EL PASO  **COUNTY**
COLORADO

County File: OAR21110

Re: Pikes Vista PUD Development Plan - CPC PUD 21-00172 and CPC PUZ 21-00172

PRELIMINARY GRADING
PLAN

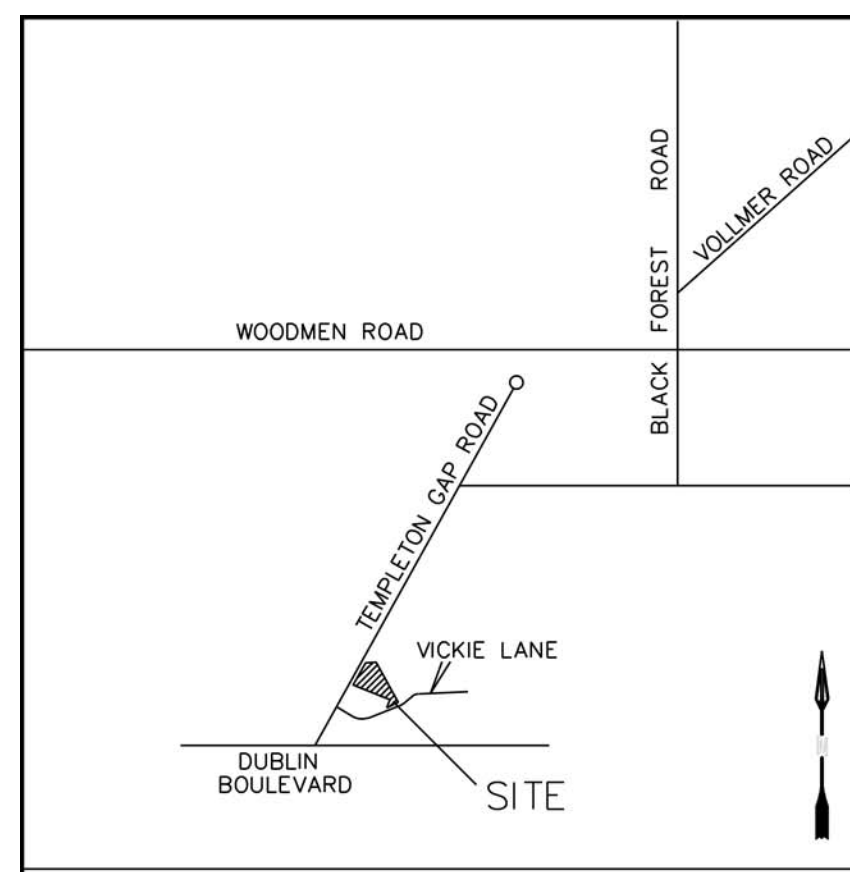
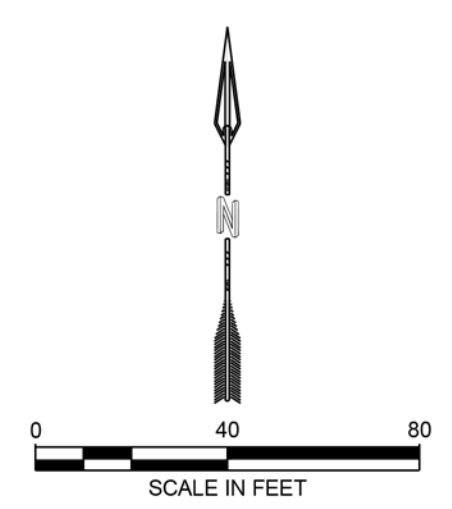
1. The County request a copy of the full Drainage Report for review. Staff only received the Existing and Drainage Map.
2. Update the proposed drainage map to include a sub-basin(s) for flows draining offsite to the south. Example: The contours at the southwest corner shows a 6857 and 6856 contour indicating drainage flows offsite. Flows draining to the south into the property within unincorporated El Paso County must be shown to be less than or equal to existing condition.
3. Relocate the pond emergency overflow to discharge south onto Vickie Ln roadside ditch.
